Subject: RE: Planning Permission Ref 21/00673/FUL  
Date: Friday, 5 April 2024 at 15:21:17 British Summer Time  
From: HOOPER Cleo  
To: Karen Price, REFSON Charles  
CC: Emma Brown, Steve Arthurell

Subject: Planning Permission Ref 21/00673/FUL

As explained, building control have advised that as we have a single stair (only means of escape) and are a building over 11 metres (13.3m) we cannot have bike storage or any storage in any of the rooms within the staircase.

Drawing title:
DETAILED FIRST FLOOR PLAN FOR CONSTRUCTION

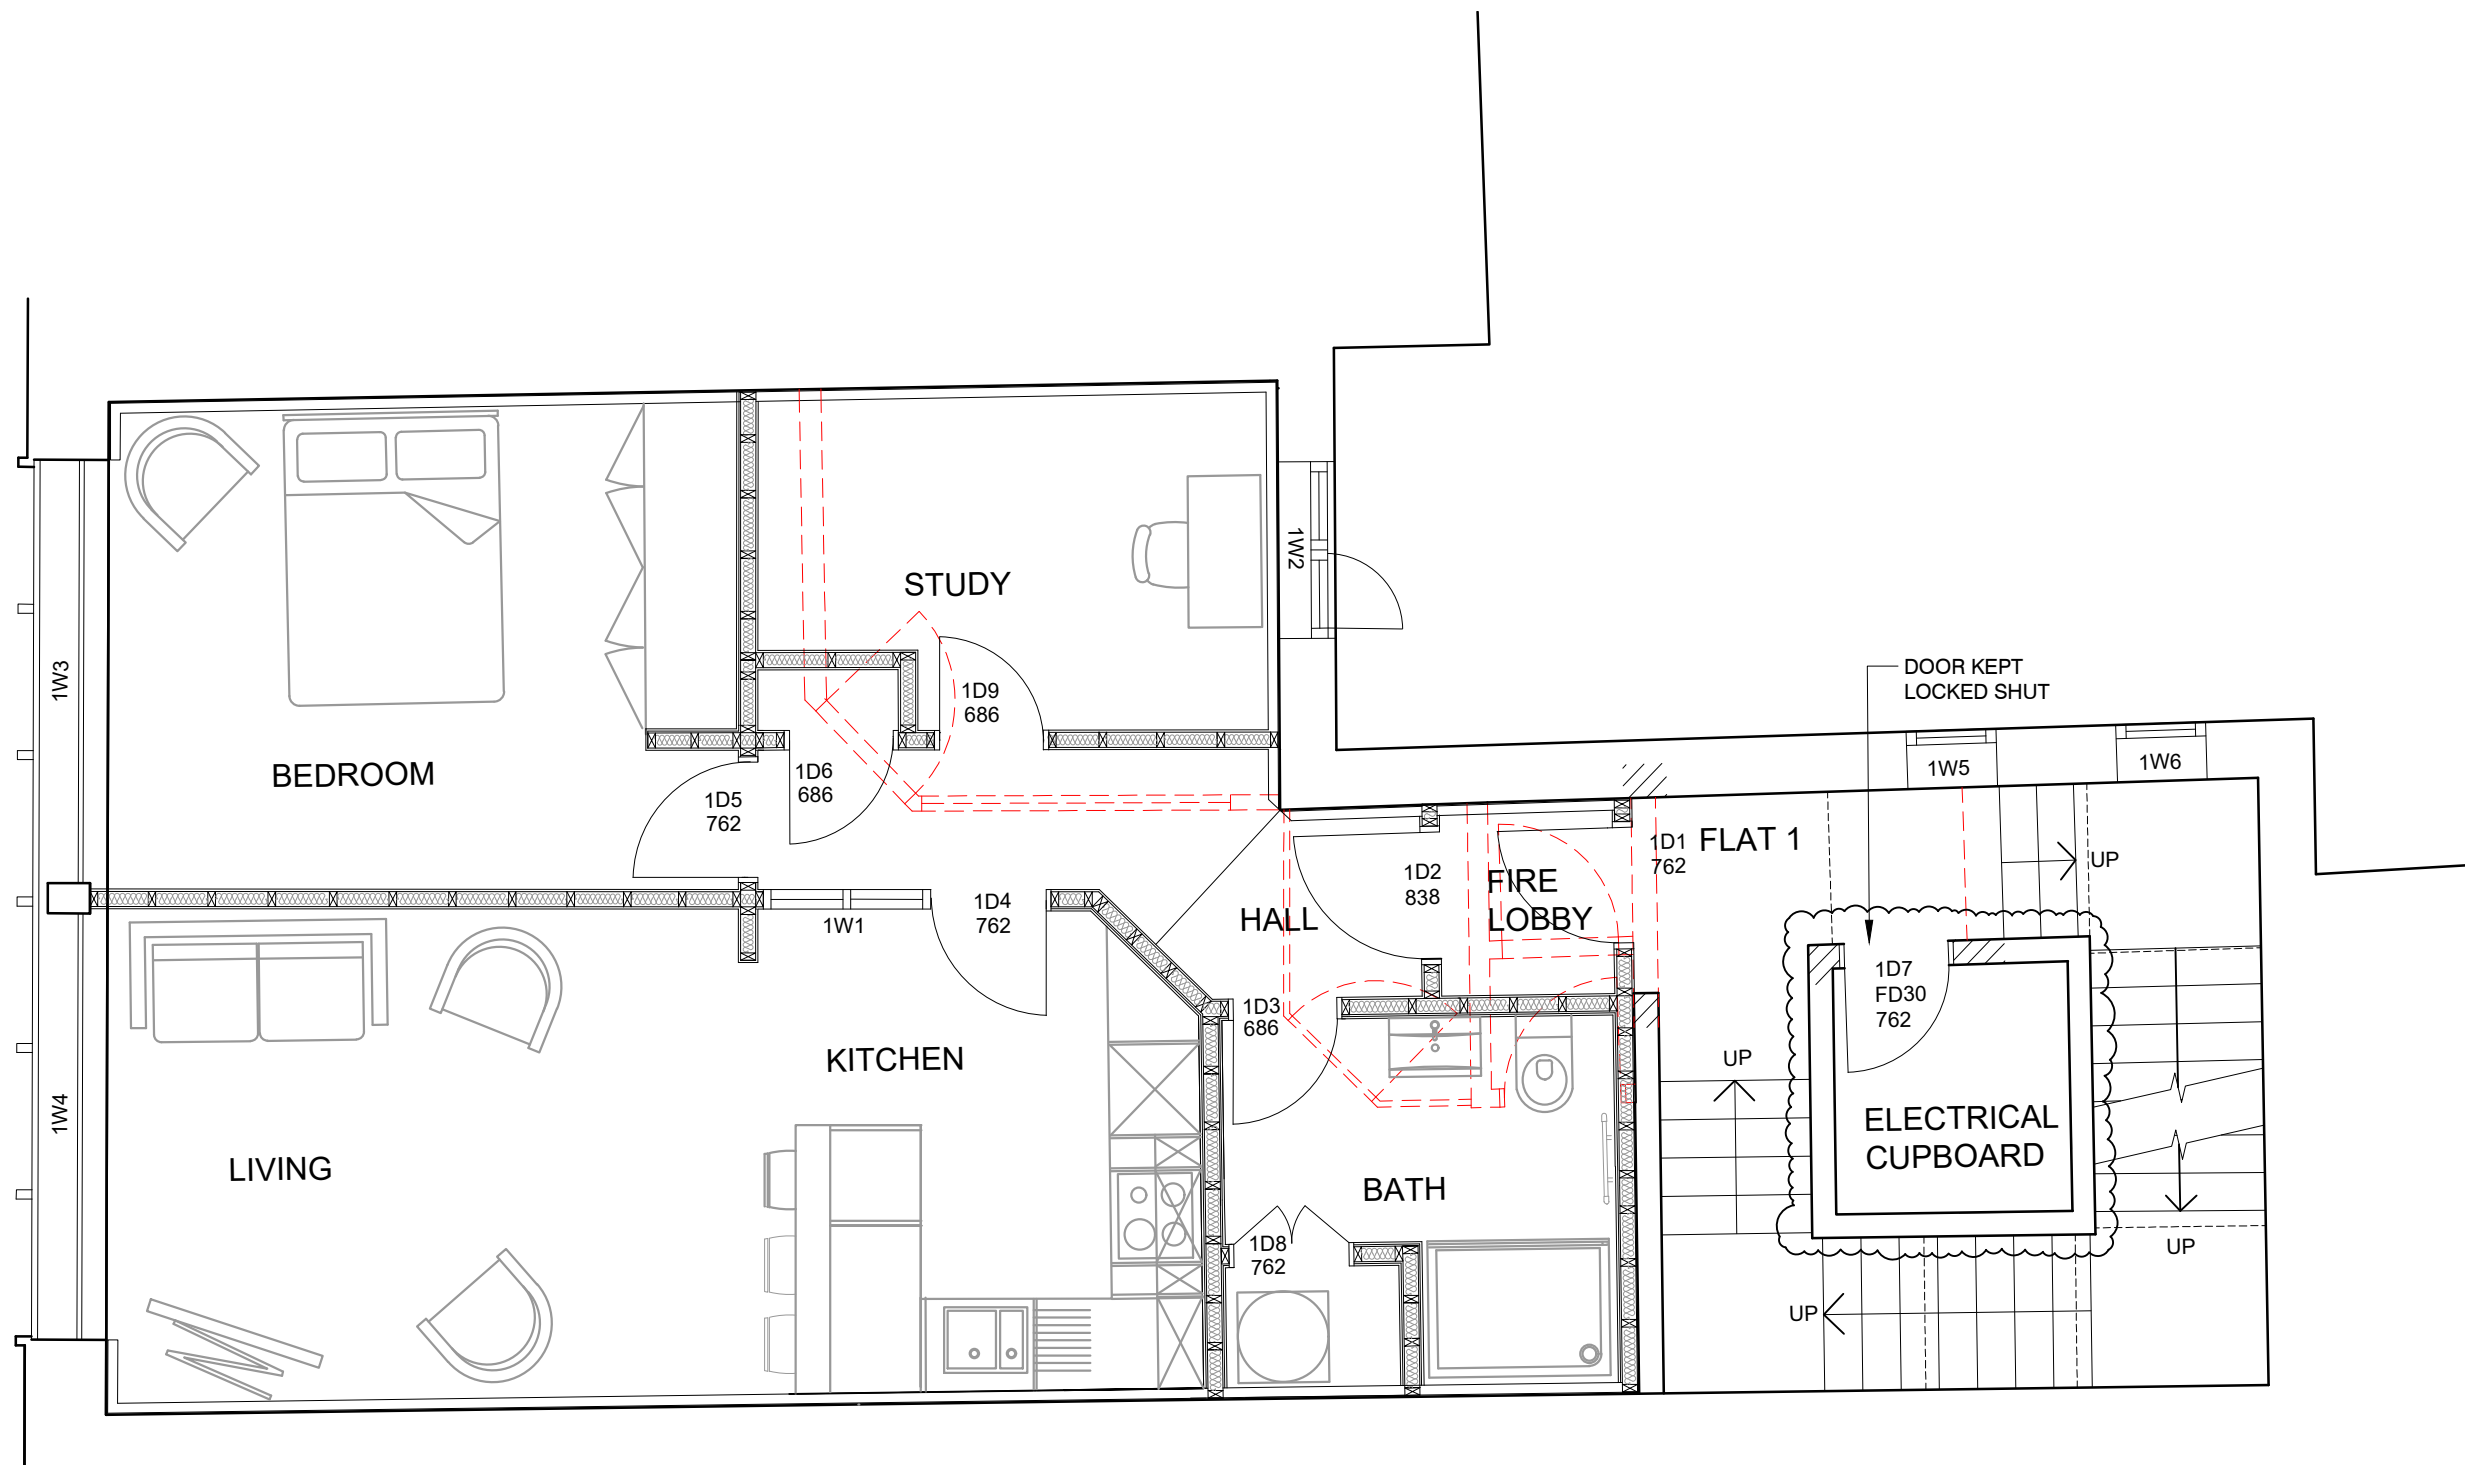
I just wanted to follow up on the e-mail from Karen, unfortunately the bike store in the staircase is not permitted under Building Regulations due to the risk to the people in the flats due to the single staircase arrangement and the height of the top floor of the building. We will not be able to accept this arrangement as part of their Building Control Application, Oxfordshire Fire and Rescue Service have also similar issues with this arrangement which we have spoken to them several times as part of our consultation process with them.

Drawing title:  
**PROPOSED FIRST FLOOR PLAN**

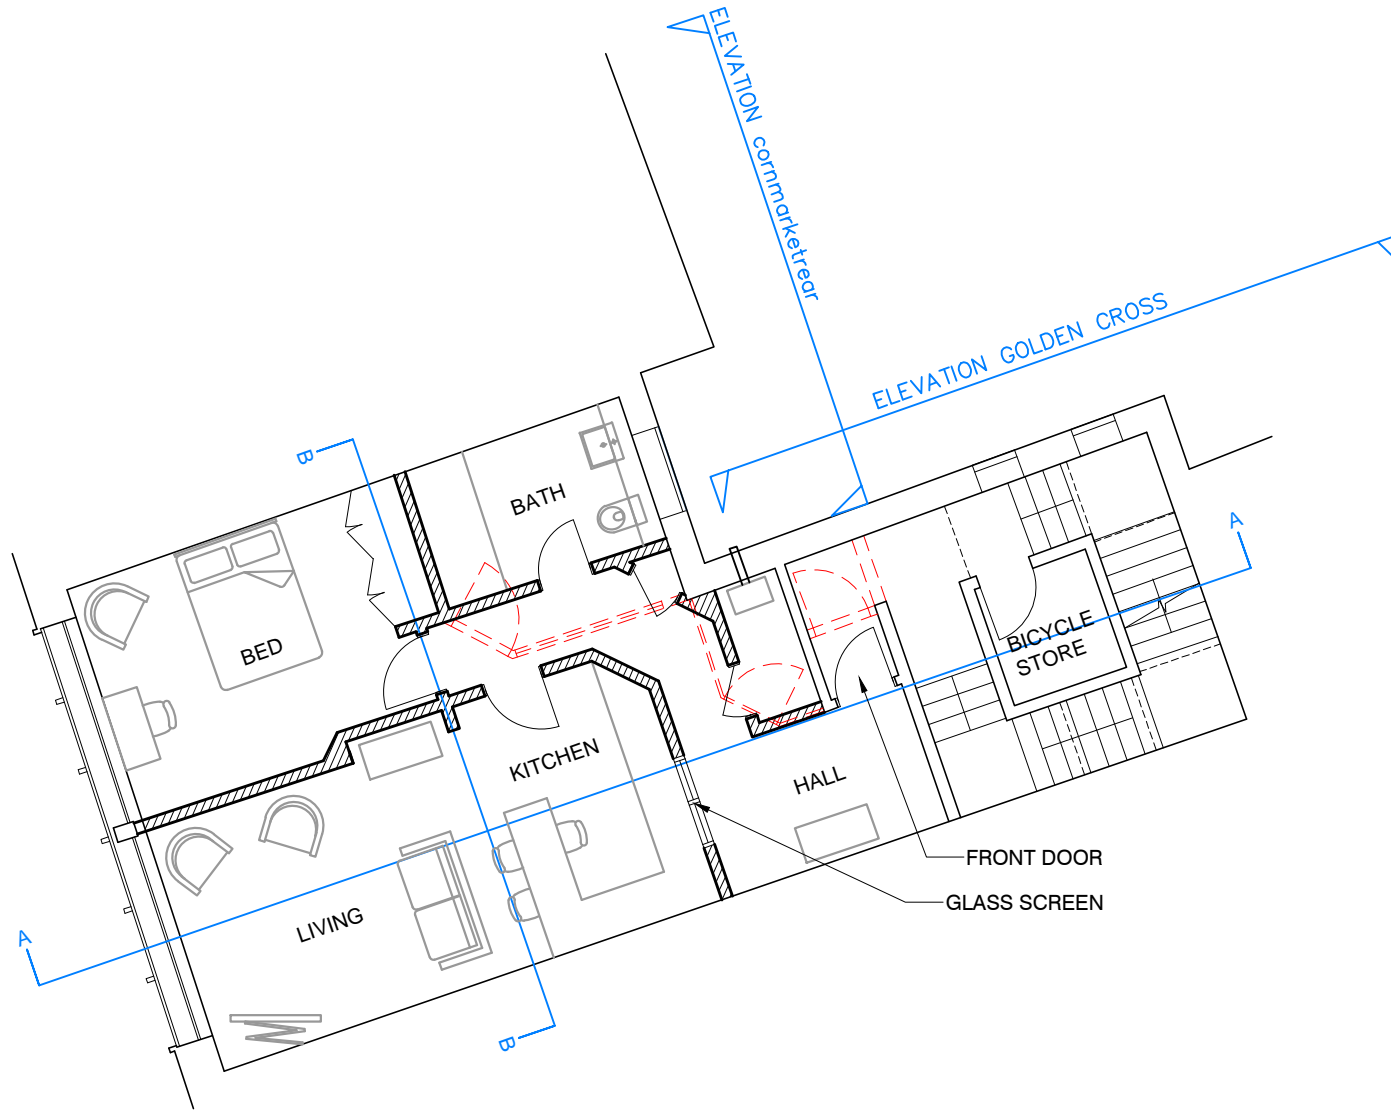
You will recall that condition 9 of our consent provided for a bike store in the room in the middle of the stairs on the first floor.

Accordingly, we are writing to request if the Council could please agree in writing that due to the requirements of the Fire Brigade and Building Control not to have storage in this space and there being no other space within the building, that we are not required to provide this cycle space.
